21 November 2013

Mr Chris Ritchie
A/Director – Industry, Social Projects & Key Sites
Department of Planning and Infrastructure
GPO Box 39
Sydney NSW 2001

Re: SSD 5897 – Remediation, land forming works, and general excavation works associated with the future basement area, Hickson Road, Barangaroo

**Figure 1** – Approved temporary stormwater diversion (SSD 5897)

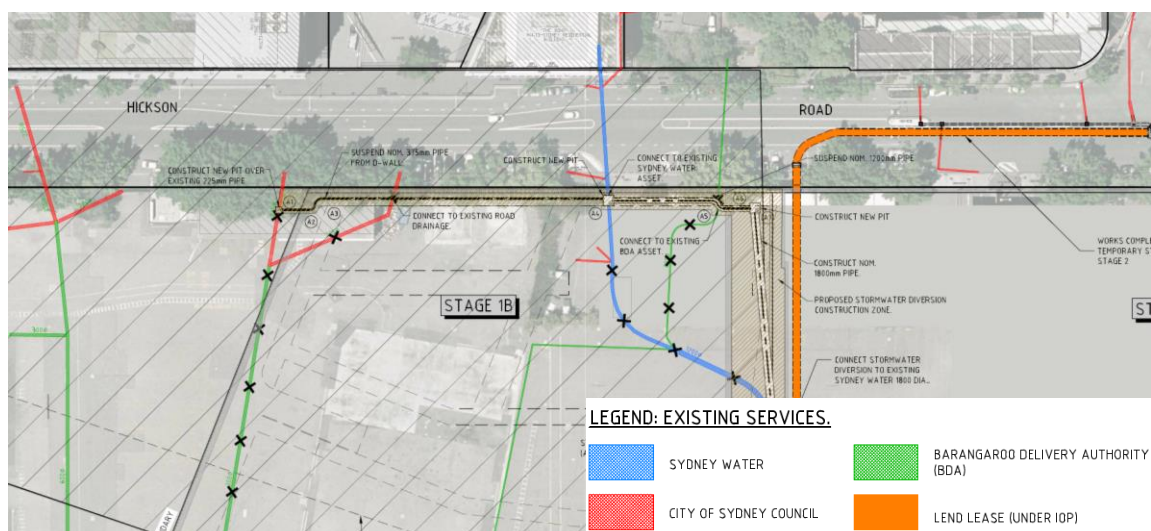
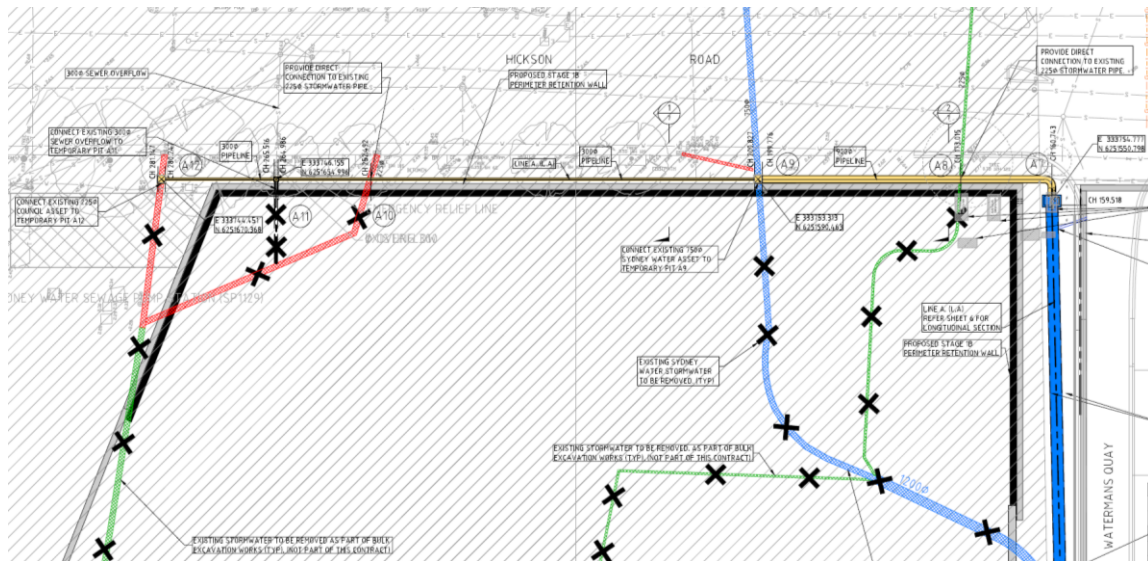
- 7. Comments on Temporary Deviation**
- Consistent with previous advice, the proponent should check the hydraulic capacity and performance of the temporary system. This would ensure existing capacity is maintained and offset the impacts associated with flattening the pipe grade. Specifically, the proposed Line A (suspended 355mm diameter pipe) is not considered adequate

- Sydney Water requests the junction to Pit 13 meet the detail provided below. Alternatively all junctions to pits must not be at 90 degrees, preferably at minimum of 30 degrees. This ensures improved hydraulic performance, especially during flows approaching full pipe. While the plan below omits reinforcement for clarity, structural details will need to be included.
